Our Ref: 26117/1

Re: Lead Local Flood Authority Response
Land off Chatburn Road Clitheroe BB7 4JX Ref: 3/2026/0315

We write to you in reference to the Lead Local Flood Authority (LLFA) feedback, dated 24/06/2026, received on your planning application on the land off Chatburn Road, Clitheroe, BB7 4JX. The LLFA have objected to the development on the grounds of inadequate surface water sustainable drainage strategy. For ease of comparison we have broken down our response on a point by point basis to match the feedback received.

RAISED PLANTER DETAIL

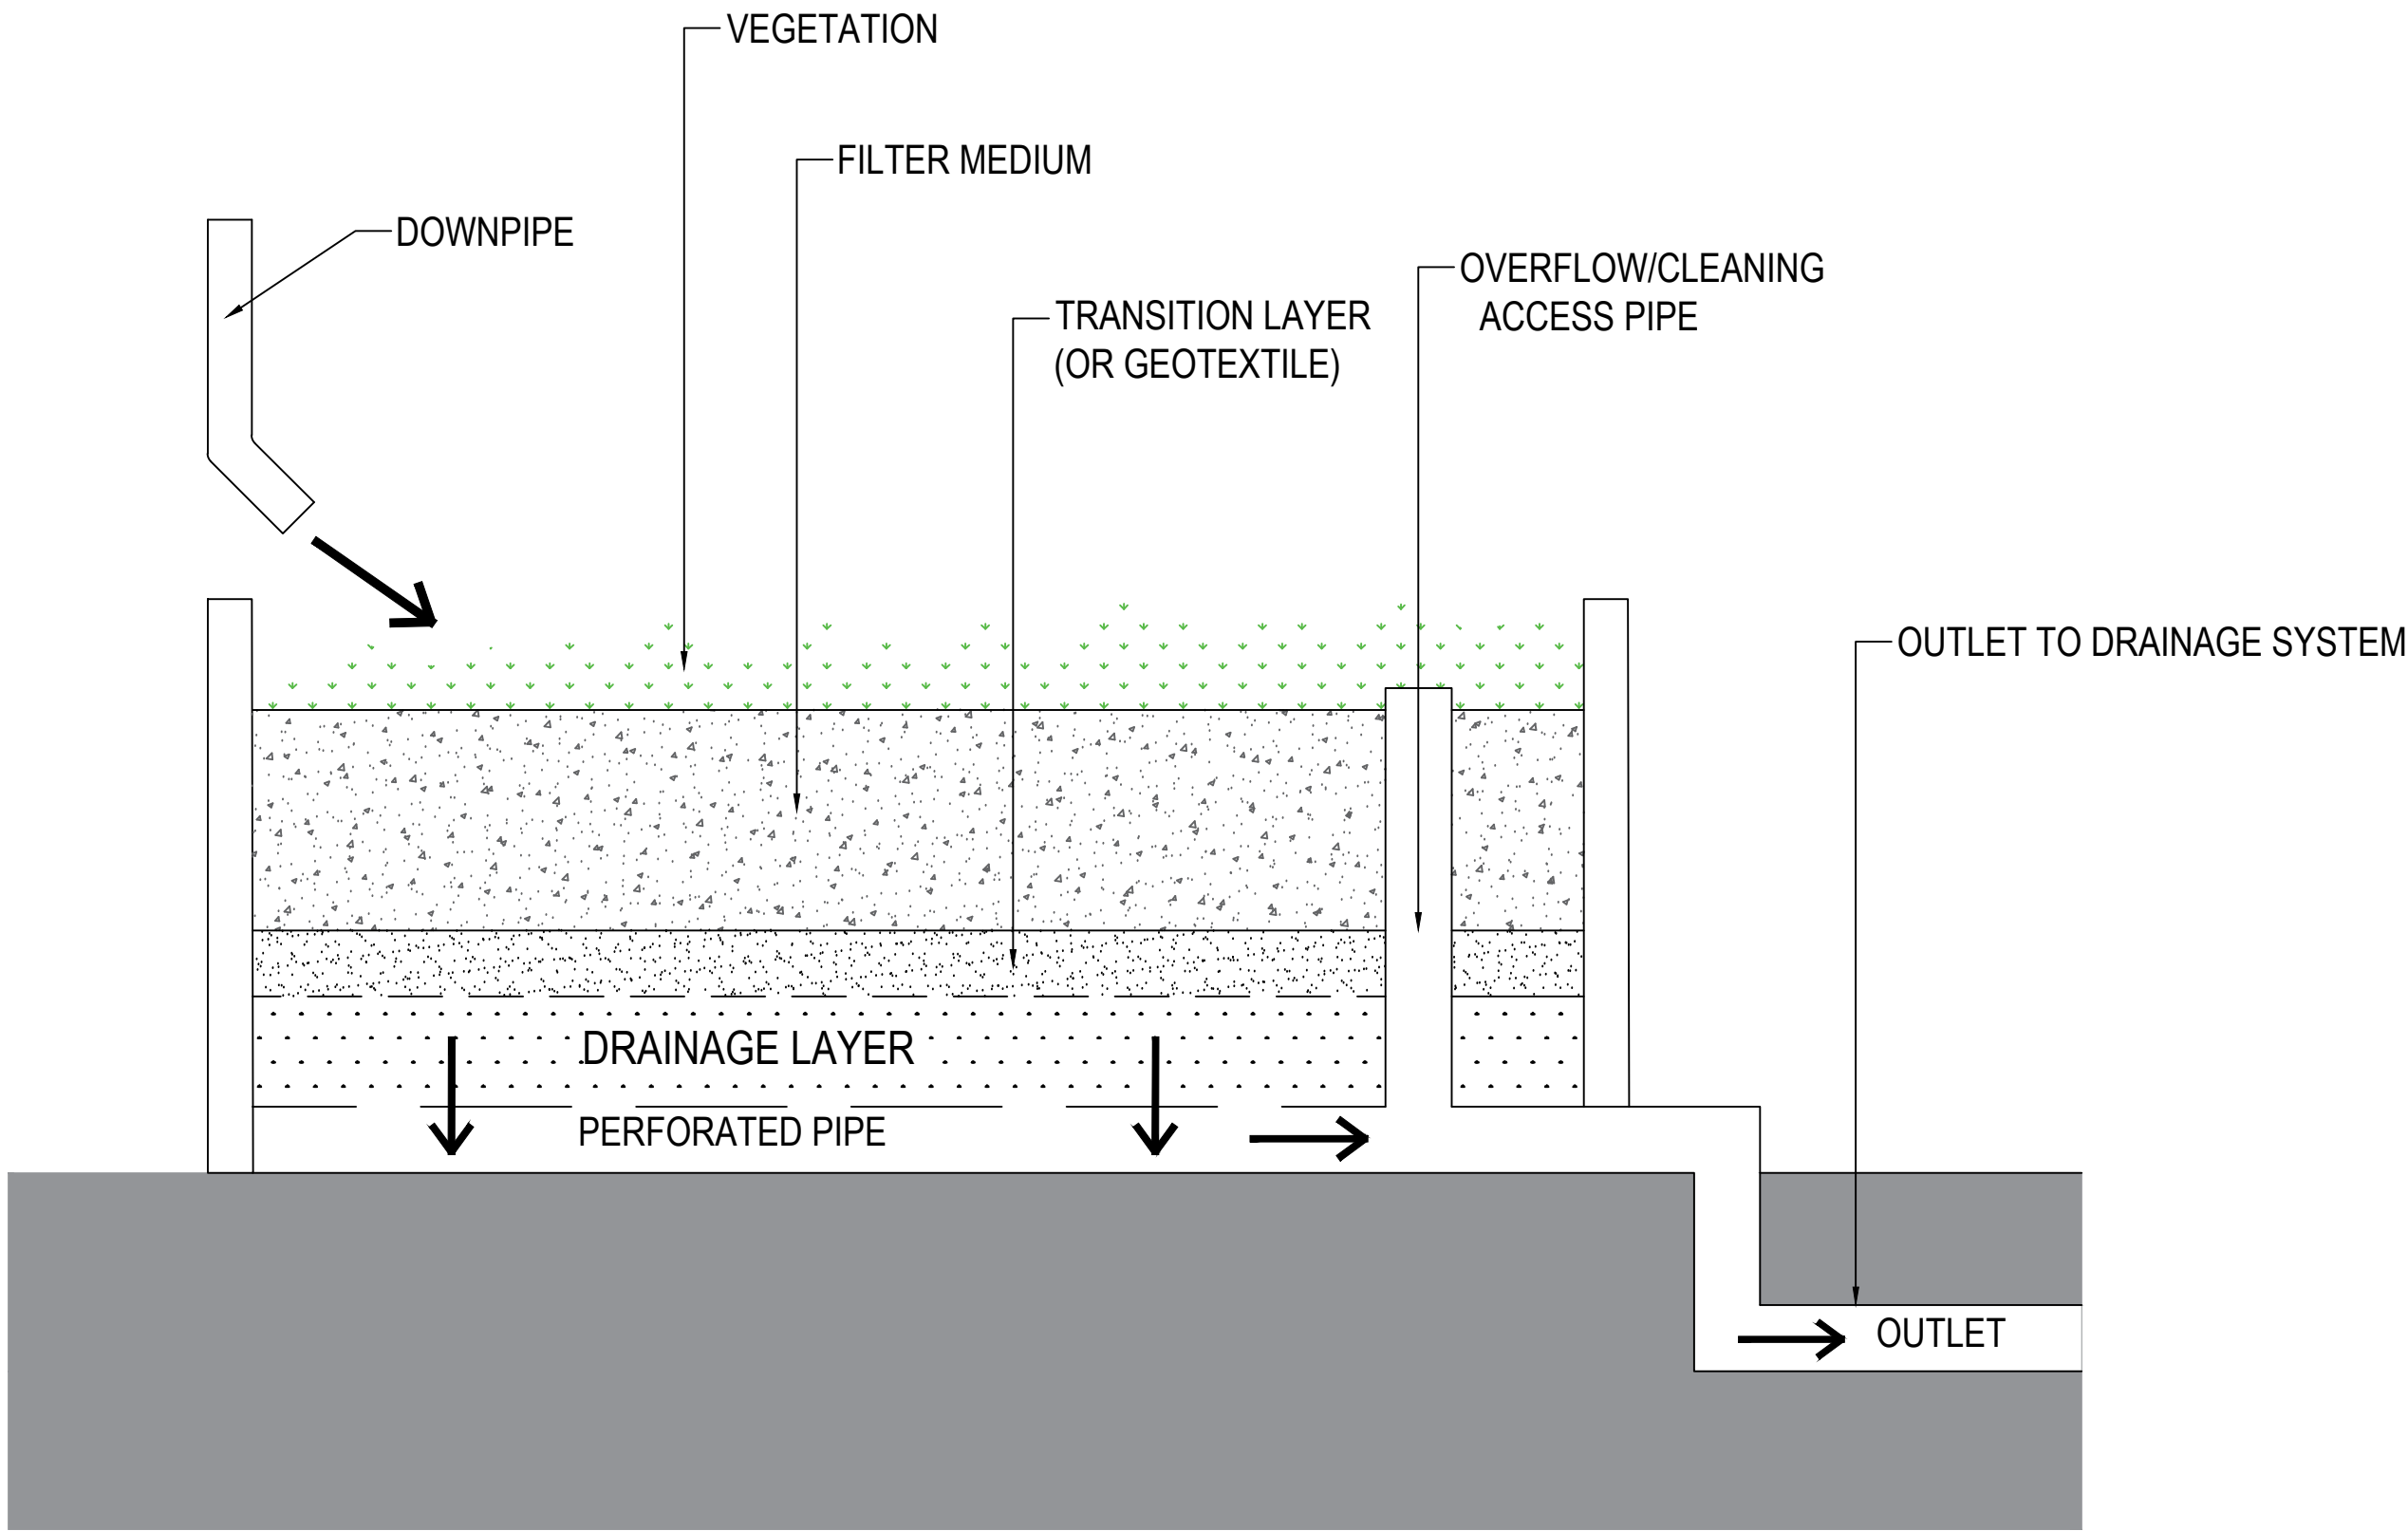
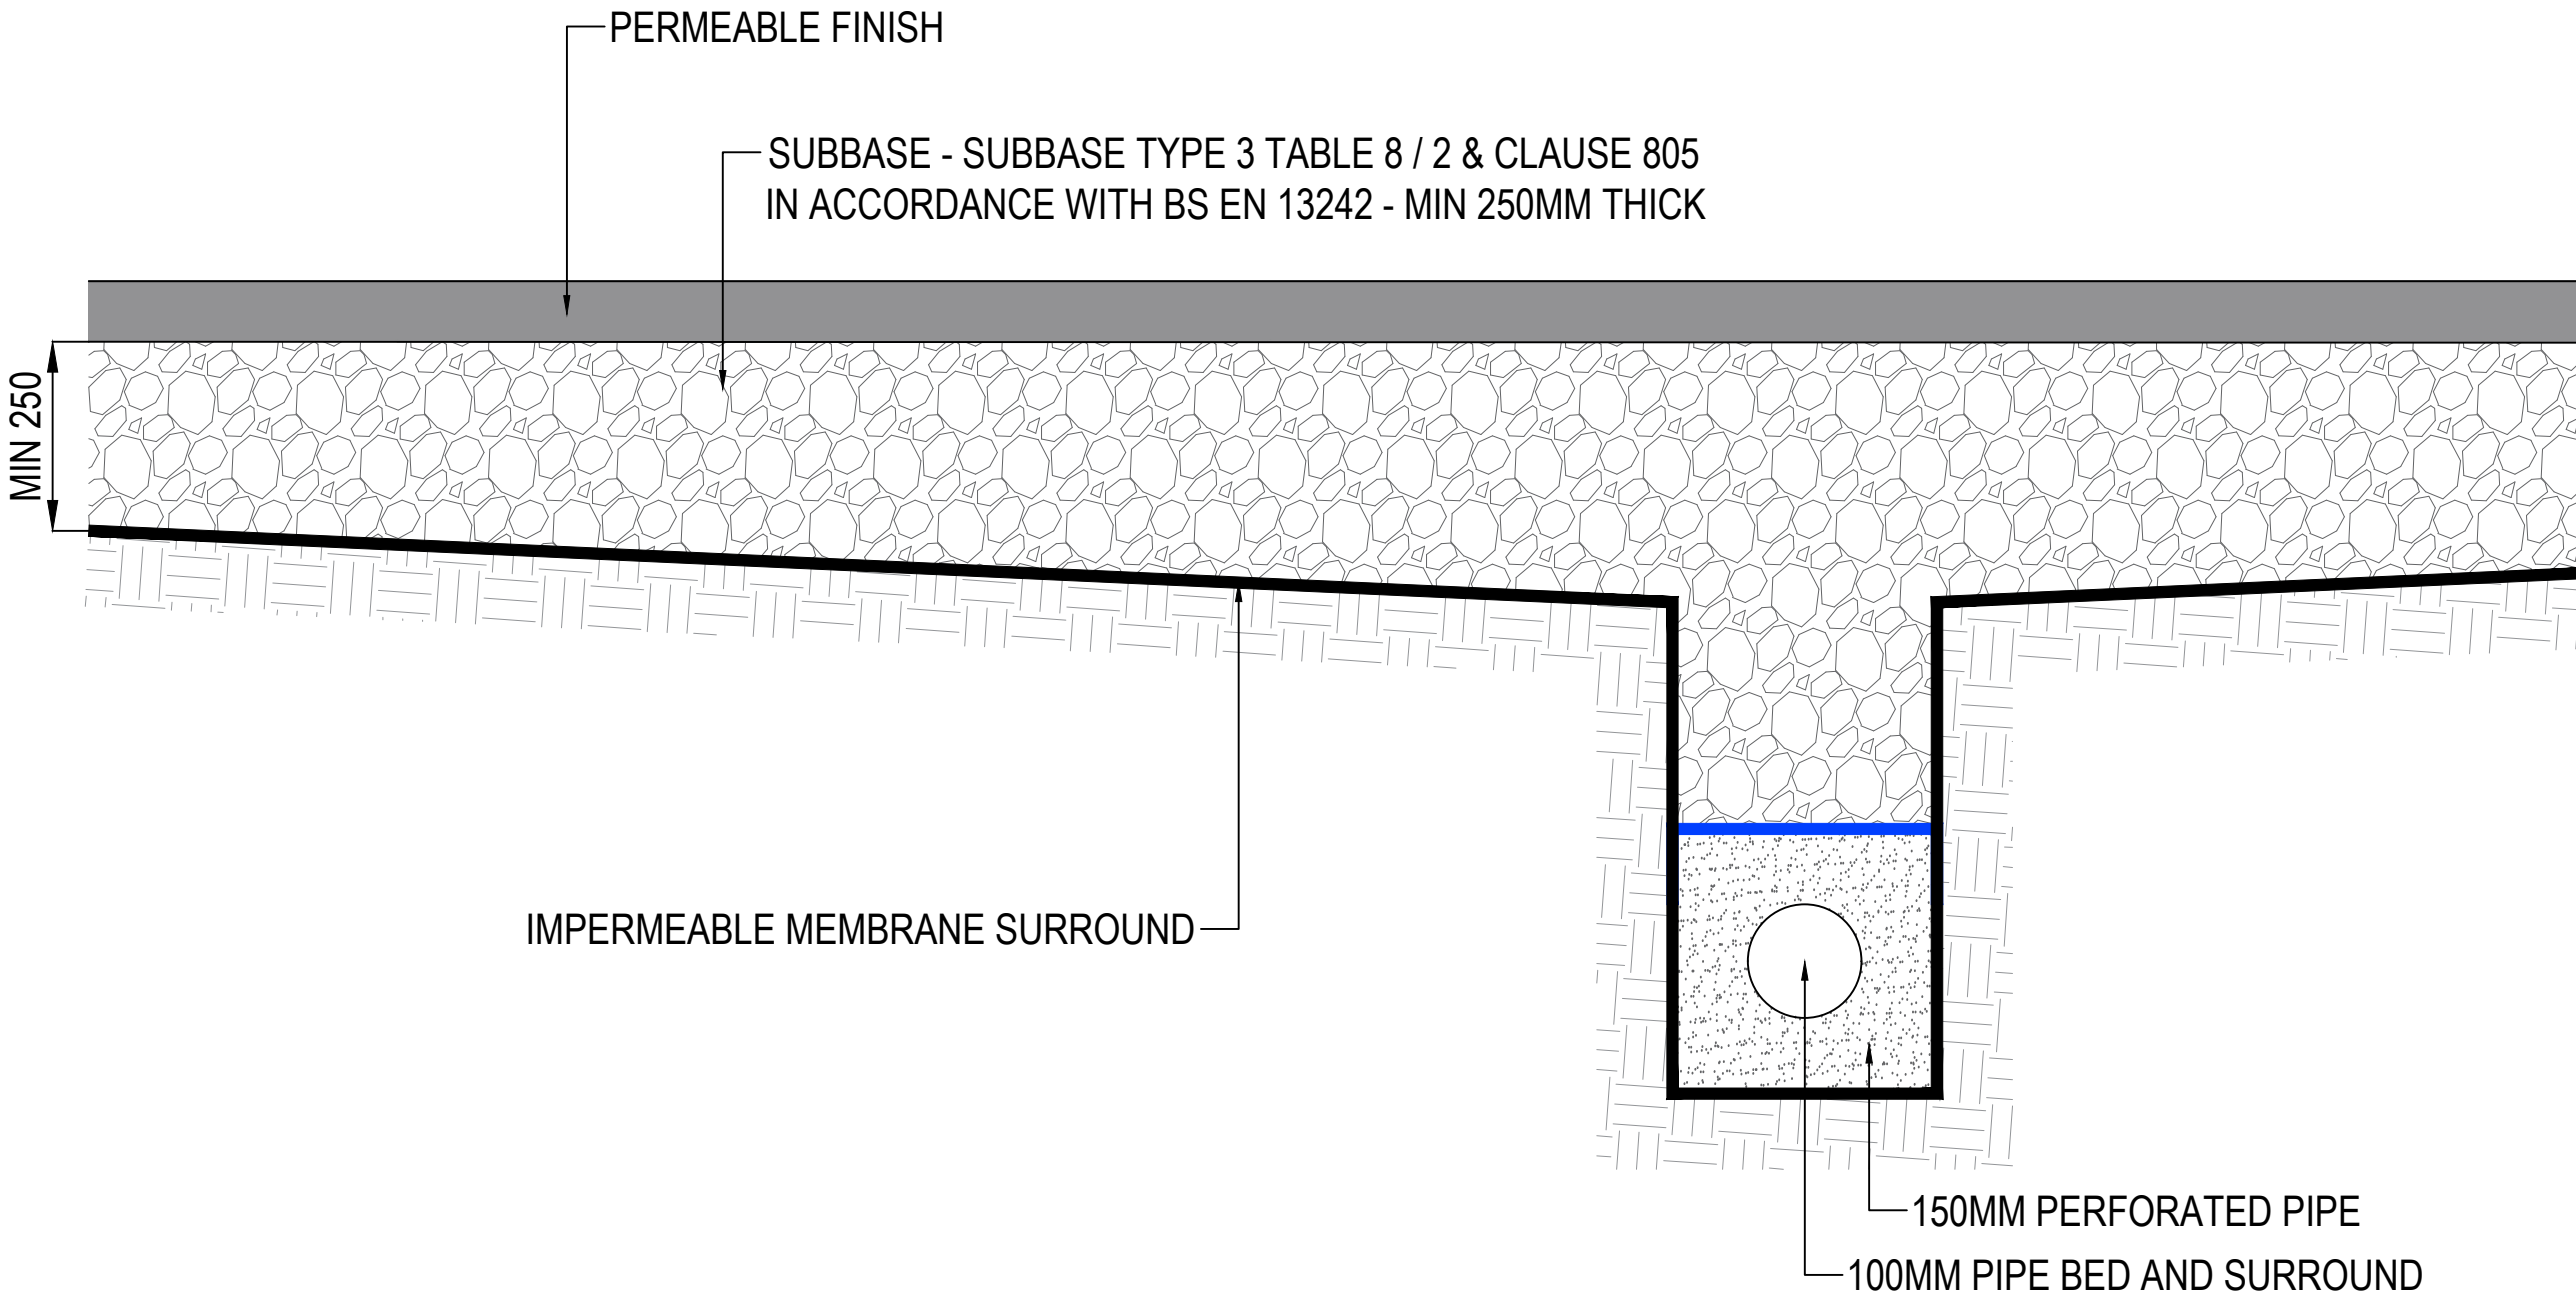
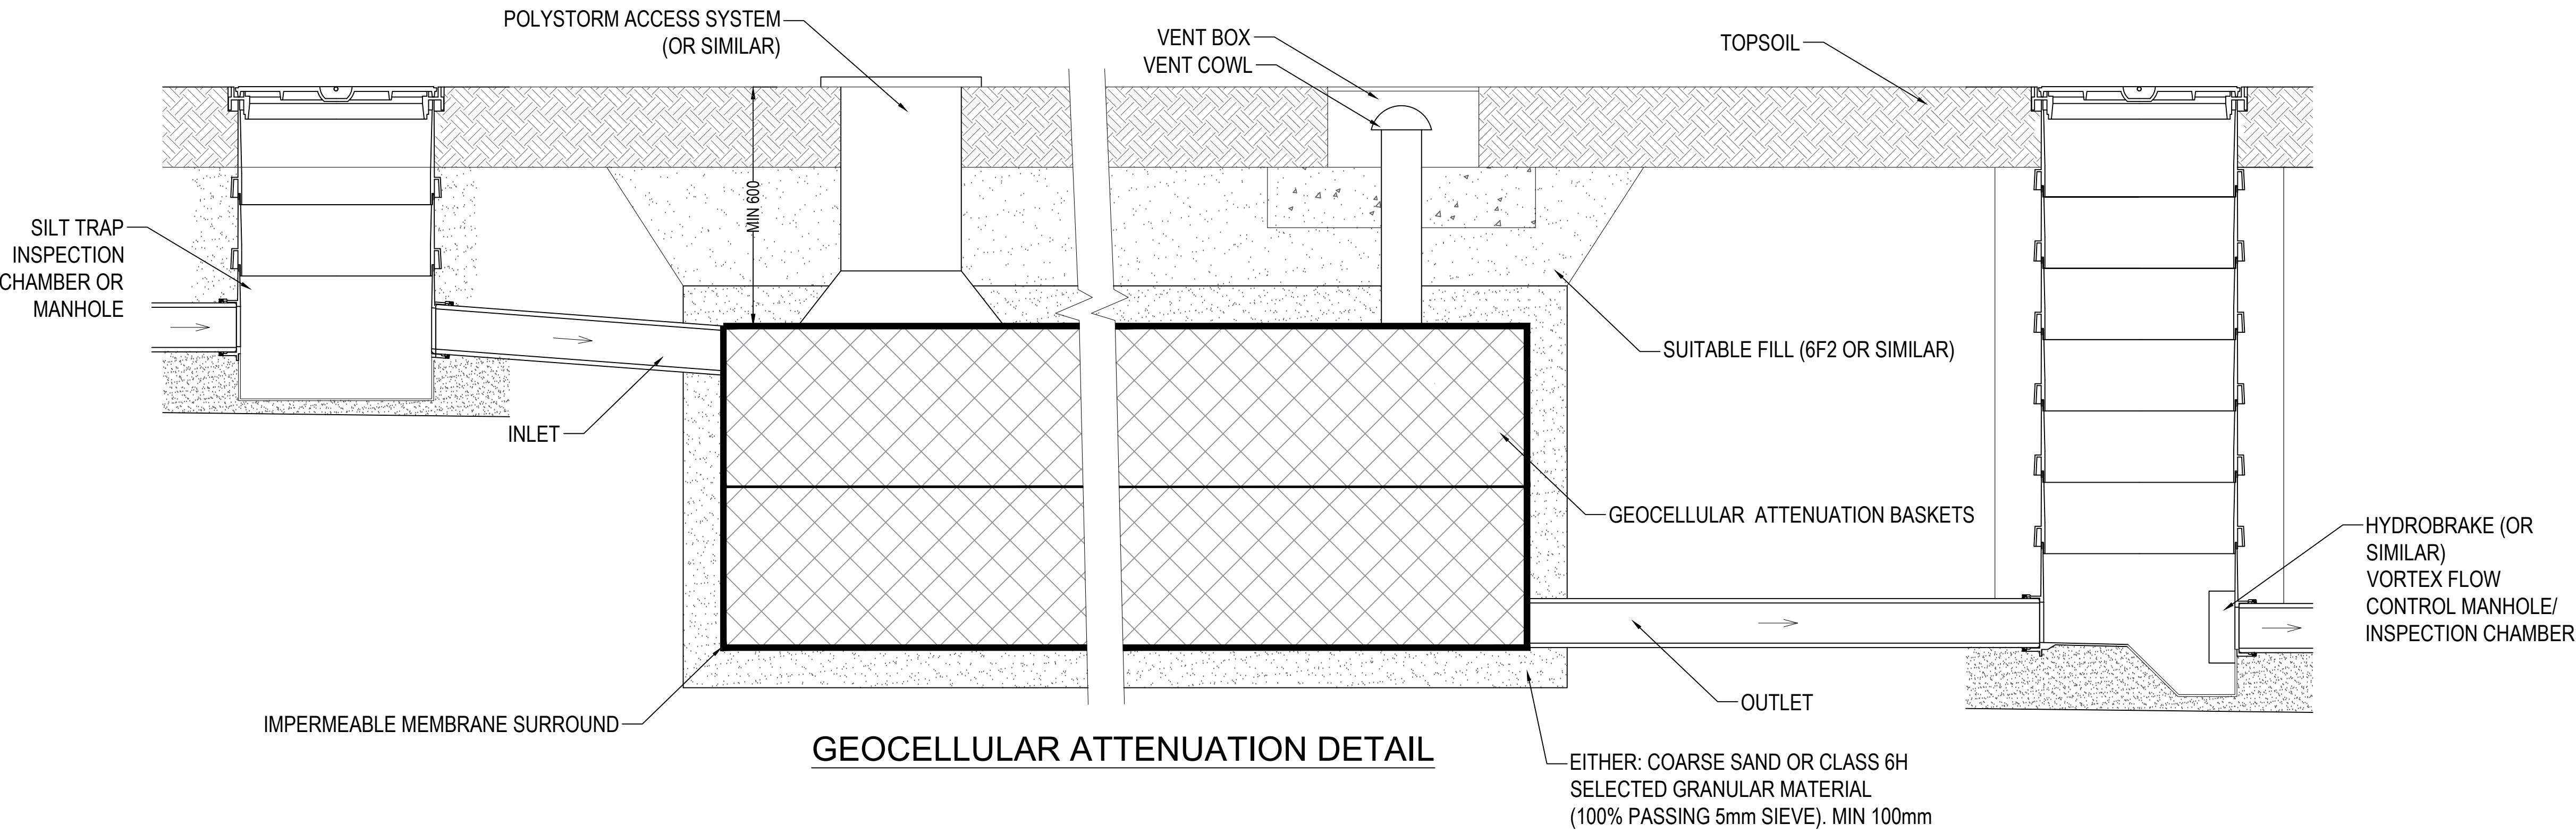
5. Failure to Manage Everyday Rainfall

All roof drainage will pass through bioretention planters which will deal with the first 5mm of rainfall at source and so comply with the standard.

Driveways are to be constructed using a permeable surface, no adjacent surface is to be drained to the permeable areas and so this is considered to comply with the standard.
